Our ref: Howlong Sand and Gravel Quarry Expansion (SSD-8804)

Subject: Request for Additional Information

I refer to Assessment for the Howlong Sand and Gravel Quarry Expansion (SSD-8804). Regarding the adjusted site layout, a new Figure 1.3 from the Environmental Impact Statement is needed.

**FIGURE 1-3 SITE LAYOUT**

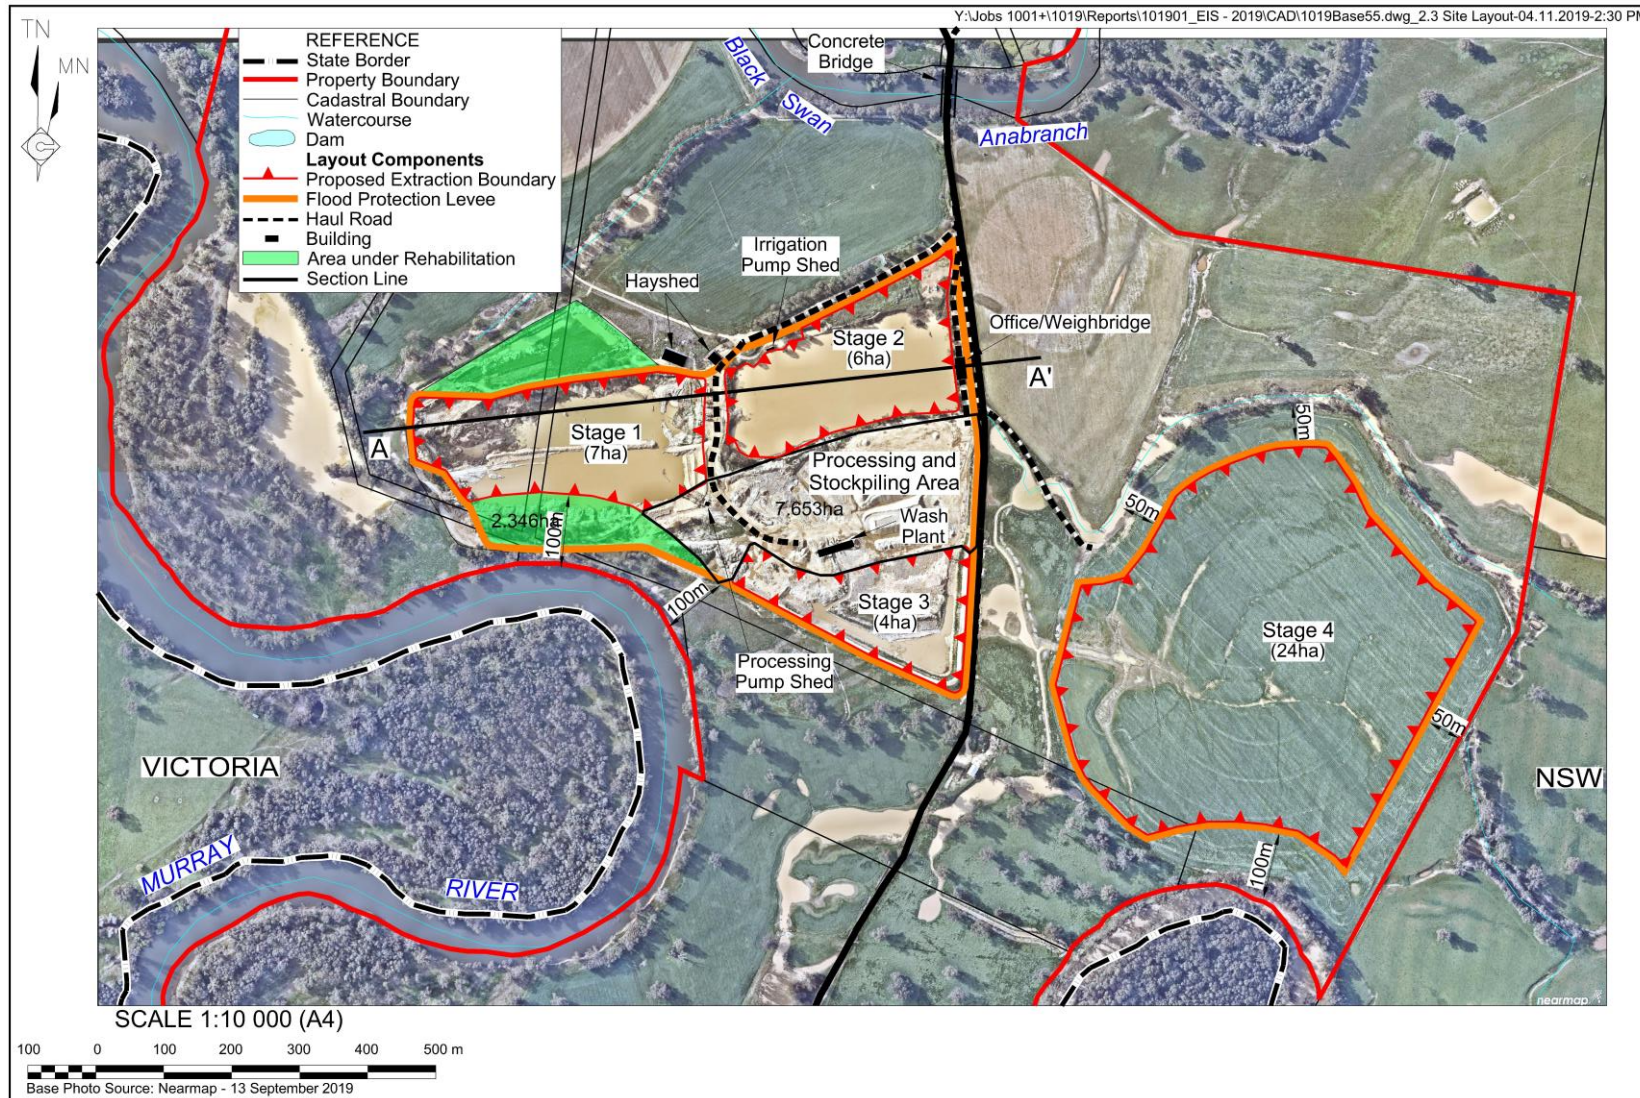
I request that you please provide an updated figure to allow finalisation of the assessment.
